17 February 2022

**SINSW - GLENWOOD HIGH SCHOOL
RESPONSE TO SUBMISSION**

Thank you for your email dated 23 December 2021, requesting the review and preparation of written responses to address concerns raised pertaining to the **SSD-23512960 - Glenwood High School Upgrade**.

Drawing Number
DA-LA-0002

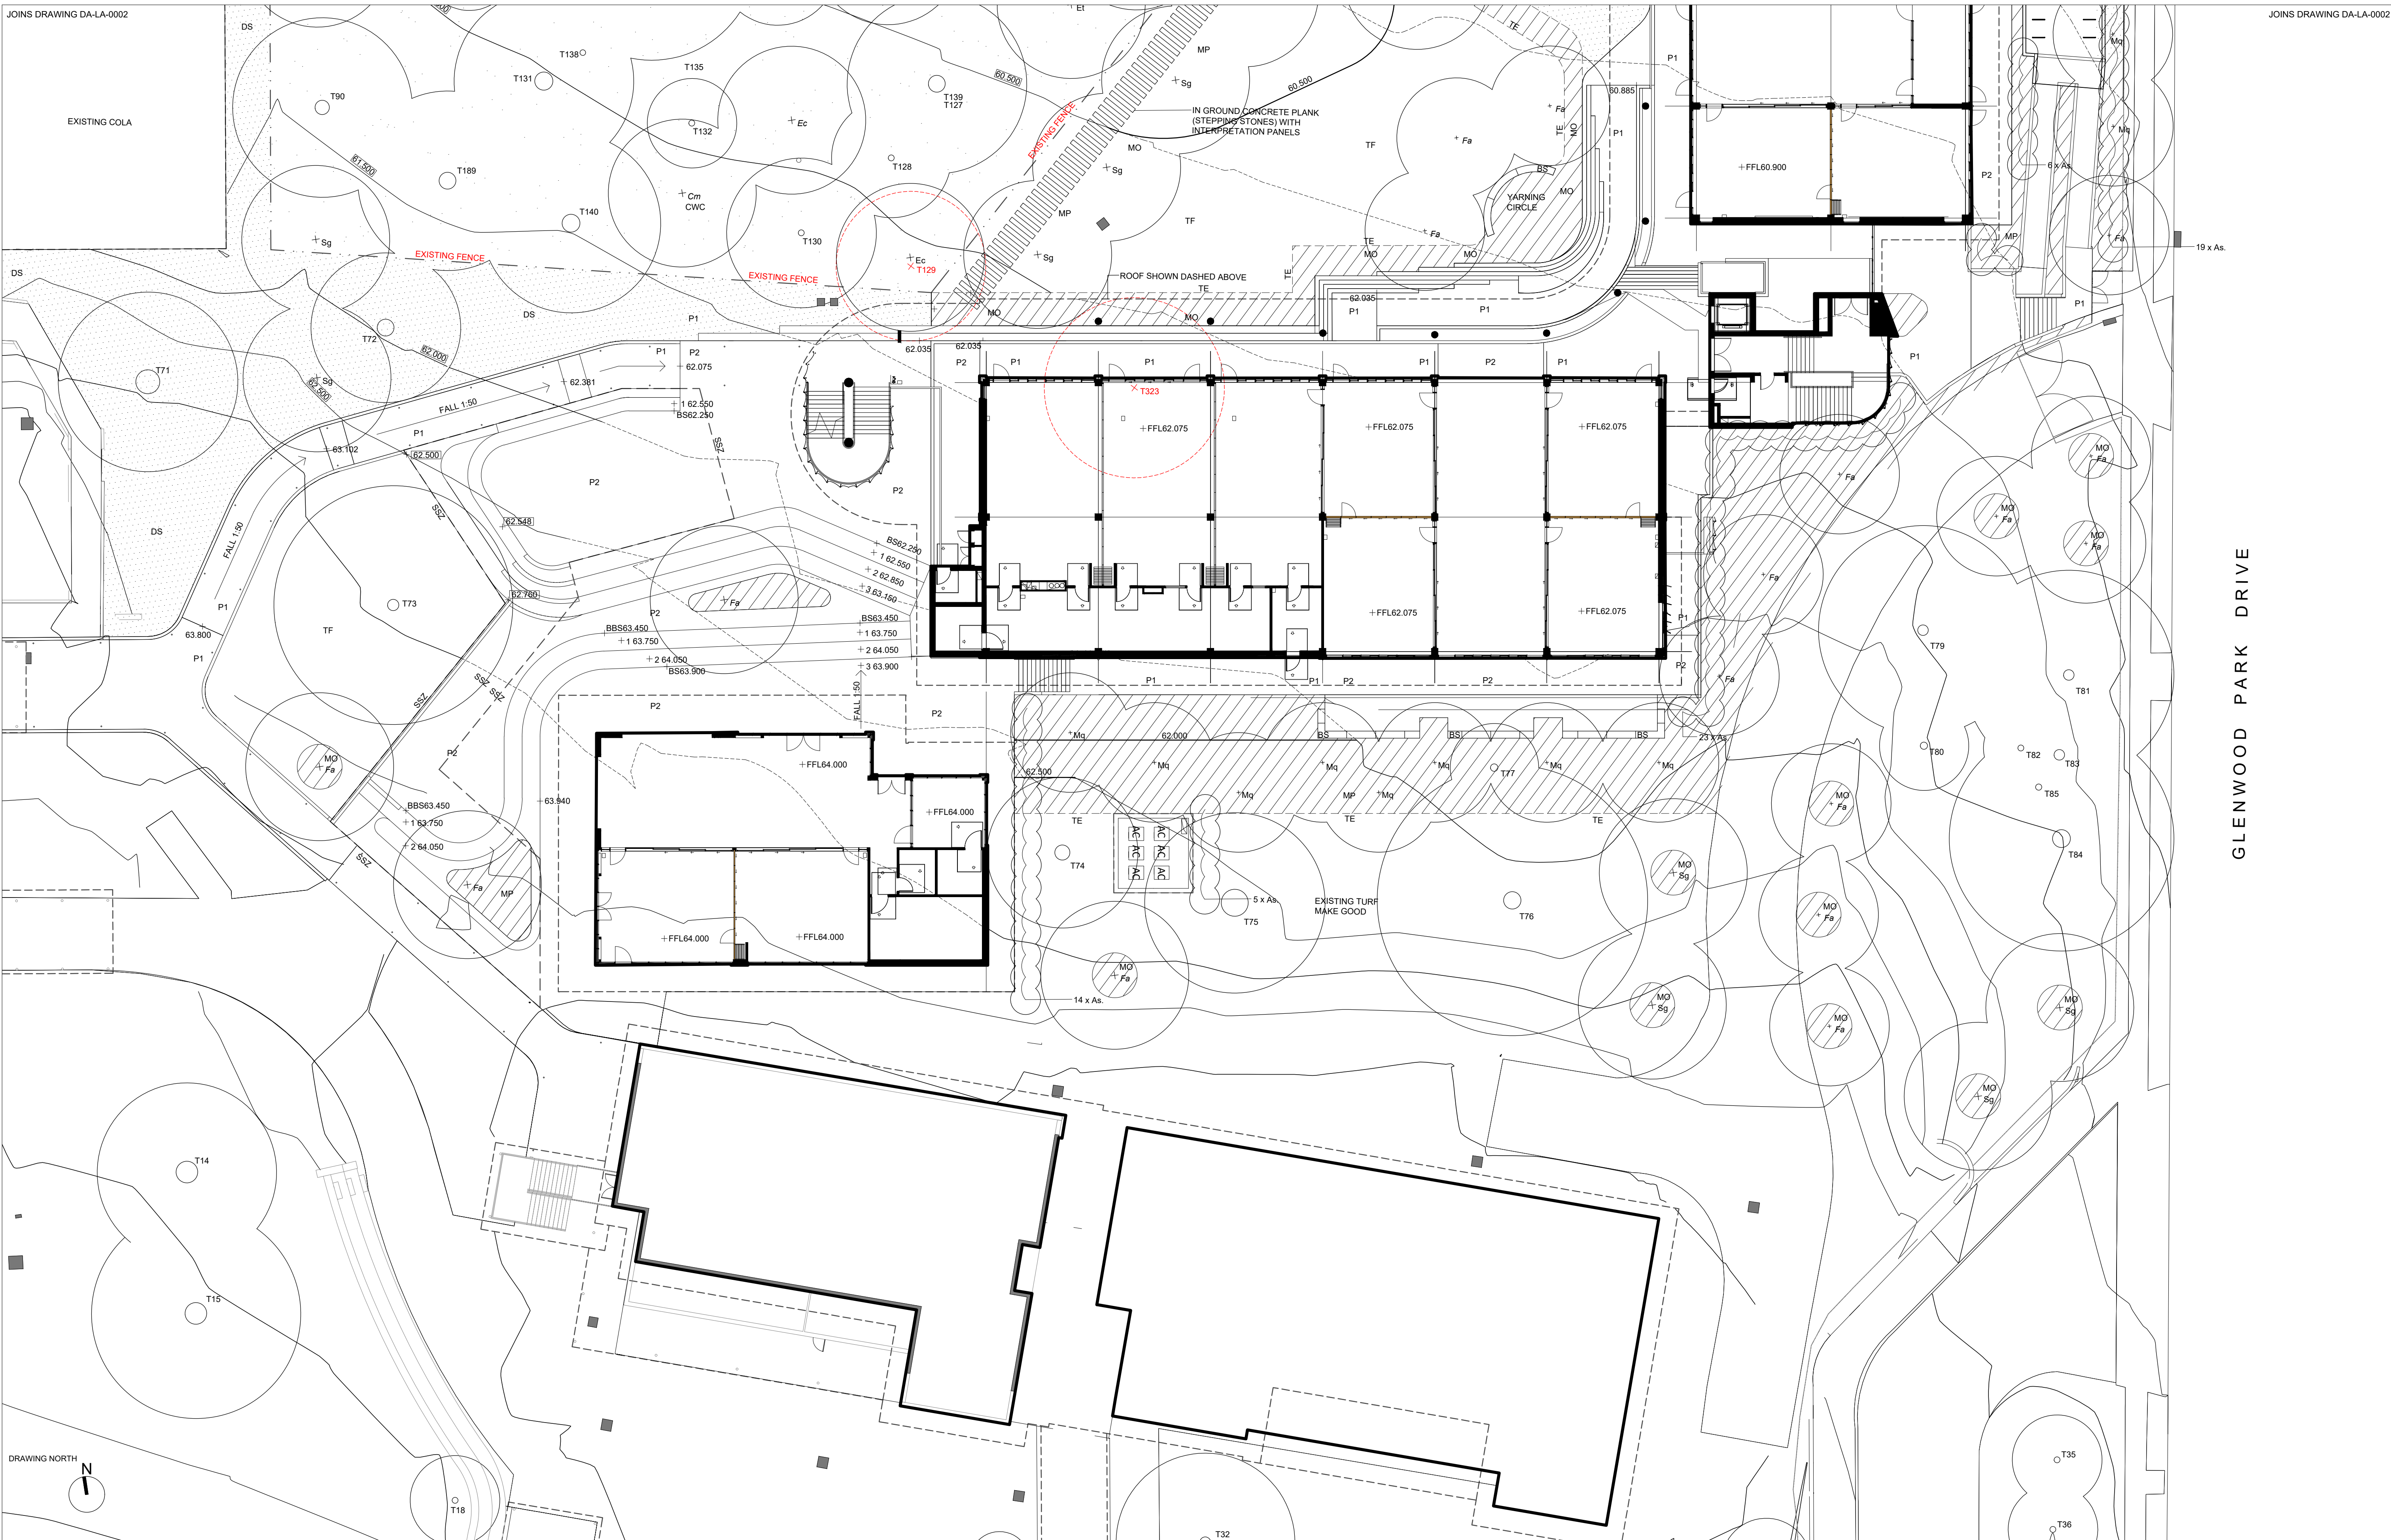
The report states that 'one high retention value tree (Tree 73) will be subject to high Impact from SSD works. There may be possibility for design changes which could allow for the retention of this tree however the current design does not allow this tree to be retained.' EES notes that the actual level of encroachment into the tree protection zone (TPZ) of the tree has not been documented in the report, however if there is potential for this tree to be retained and protected, this should be further explored.

A major encroachment into the TPZ of Tree 72 is also proposed under the subject SSD. The exact extent of encroachment is unclear however the report notes the tree may be retained subject to specific construction methodologies and timing of works. Further clarity should be provided regarding the actual measures required to retain and protect this tree.

Why the footpath has not been reinstated forming a pedestrian connection between end points of the new 'L' shaped building.

McIntosh & Phelps has developed design iterations to the existing design currently encroaching on the Tree Protection Zone (TPZ) of Tree 73 - *Eucalyptus tereticornis* (Forest red gum). The proposed design amendment option (Refer Appendix 1) minimises the encroachment to Tree 73 from 20% to 8.44% and should allow the tree to be retained.

The encroachment of the TPZ of Tree 72 - *Eucalyptus tereticornis* (Forest red gum) is 10.4% (Refer Appendix 1). Construction methodologies to reduce the impact on the TPZ identified by Eco-Logical could include;

McIntosh & Phelps has now proposed to increase stepping stone path linking the proposed new homebases to the north (Refer Appendix 1)

Figure 29: SSD/EIS – Landscape plan (PTW Architects 2021)

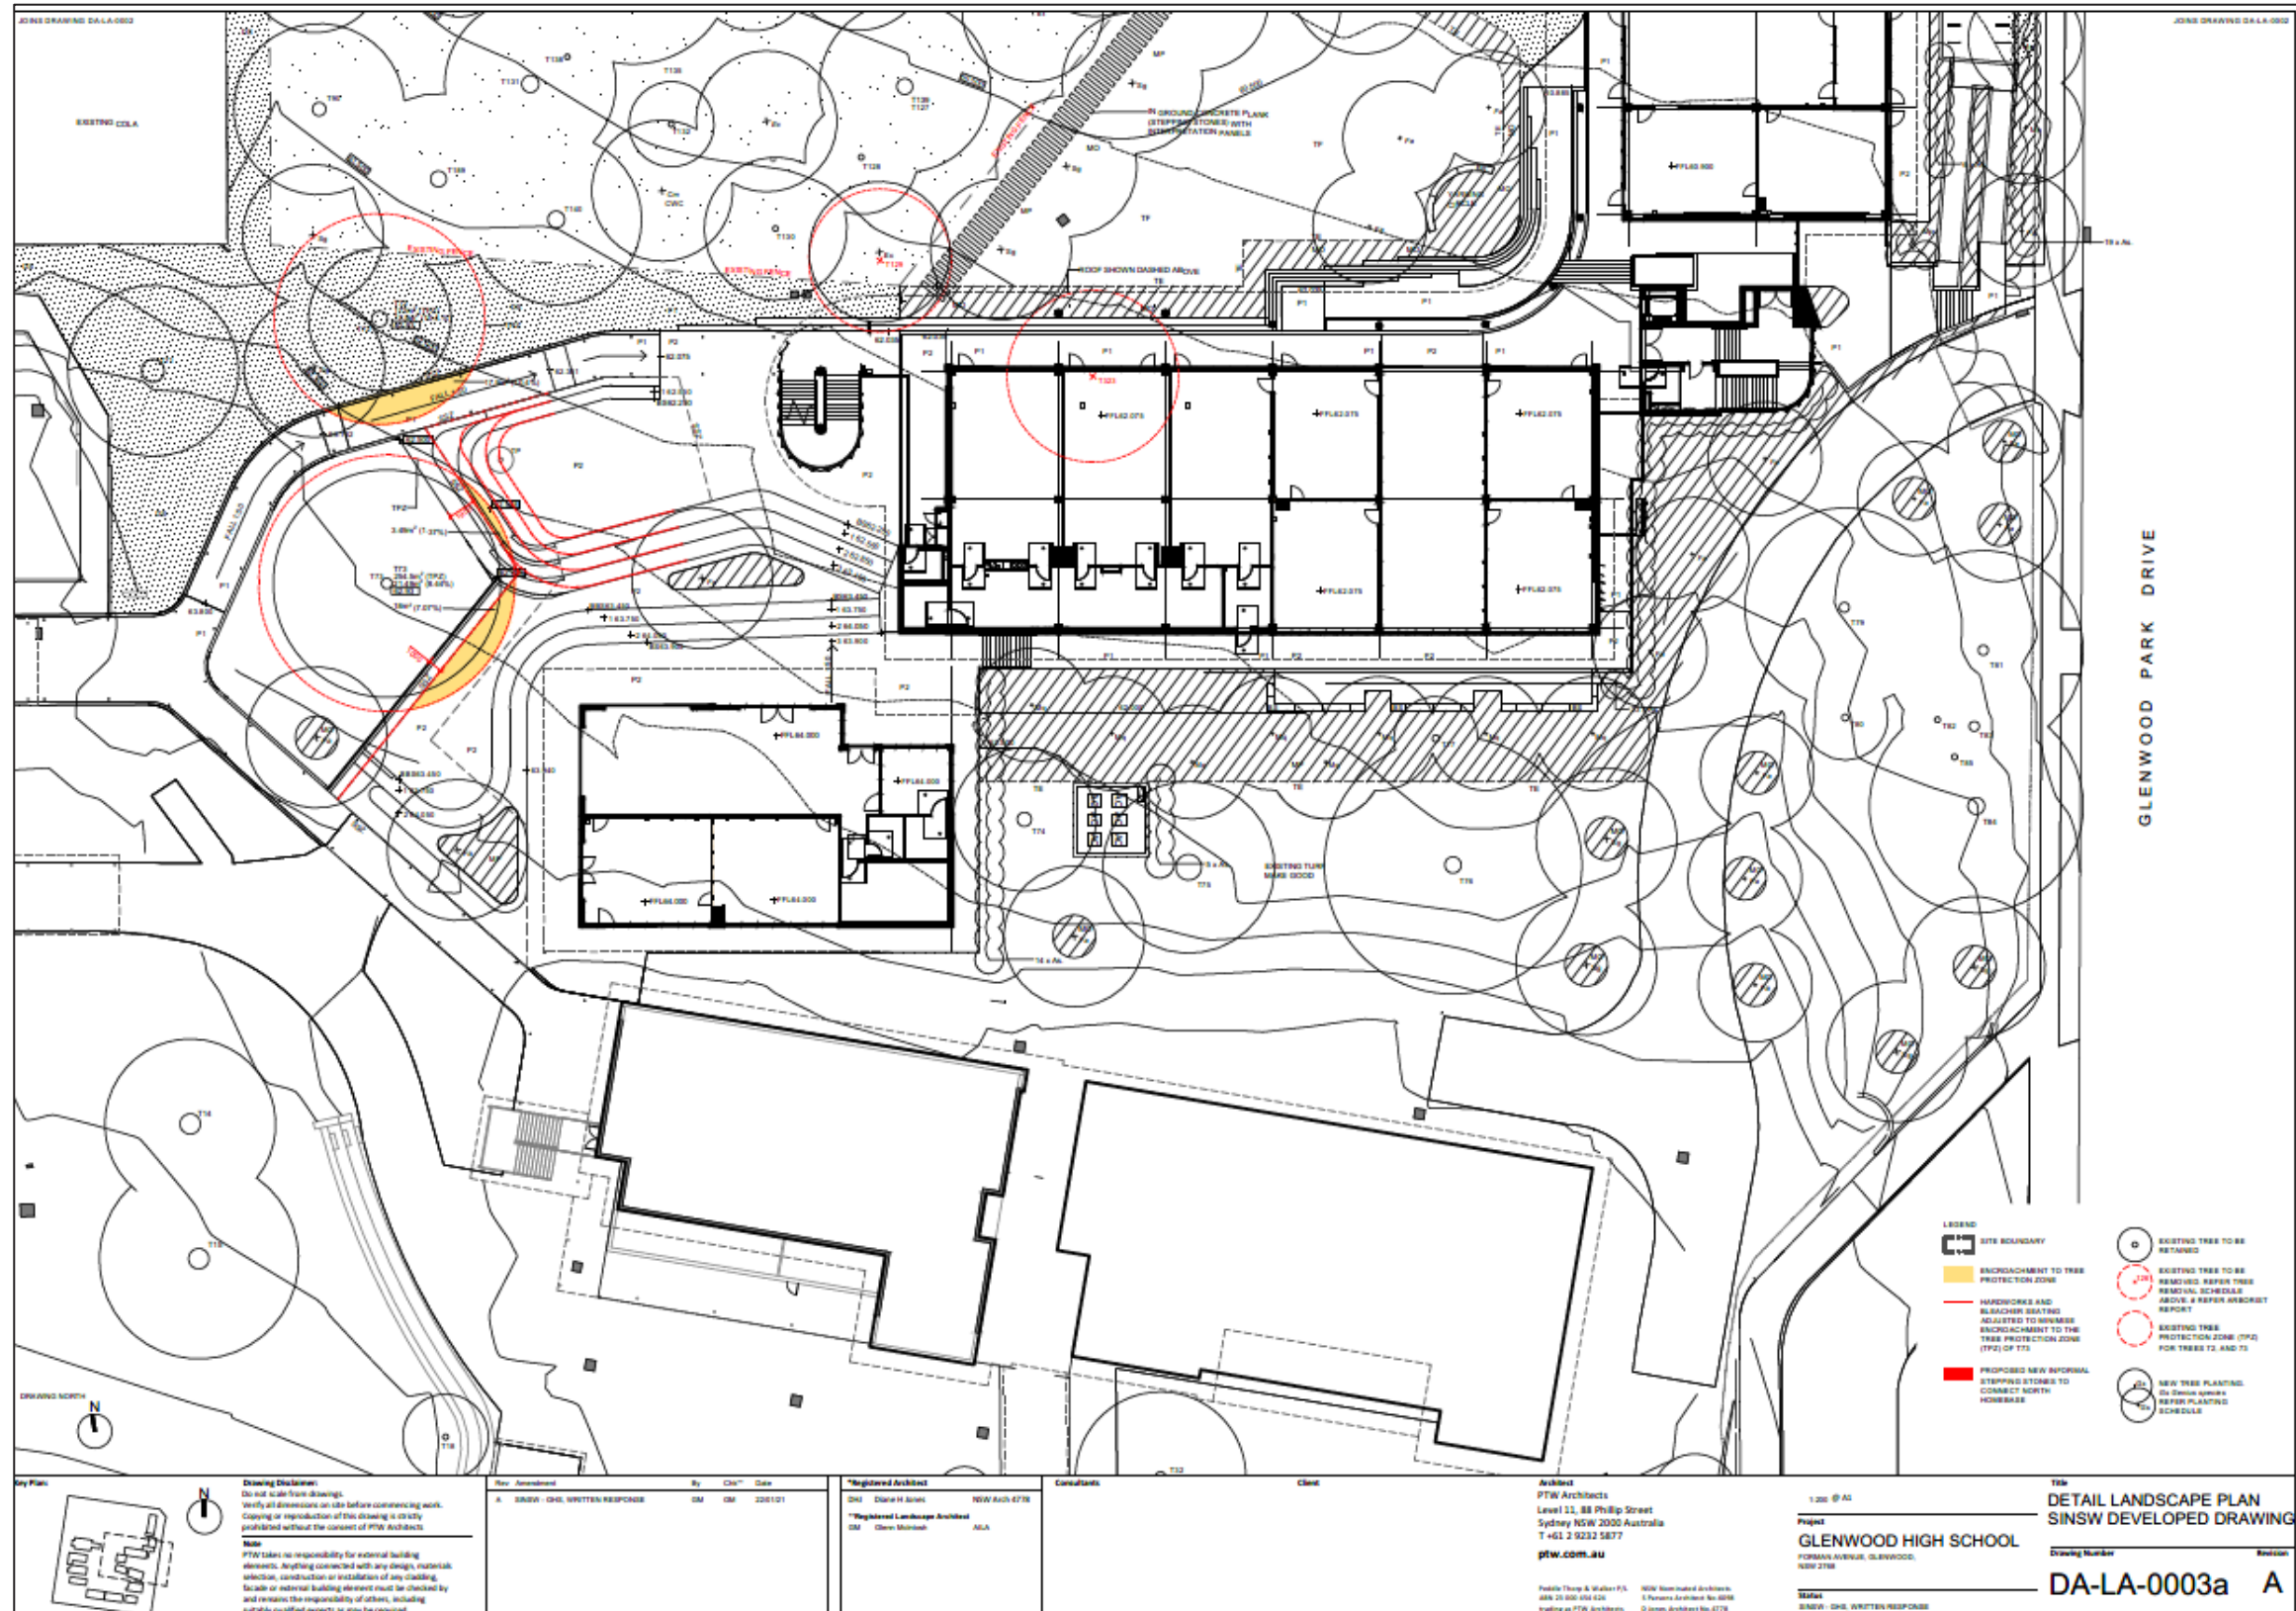
The proposal includes the removal of a highly significant tree identified as Tree 73 in the submitted Arboricultural Impact Assessment (ALA). The ALA states that there may be possibility for design changes which could allow for the retention of this tree.

Include further justification, evidence and assessment as to why a design modification cannot be achieved to provide for the retention of Tree 73.
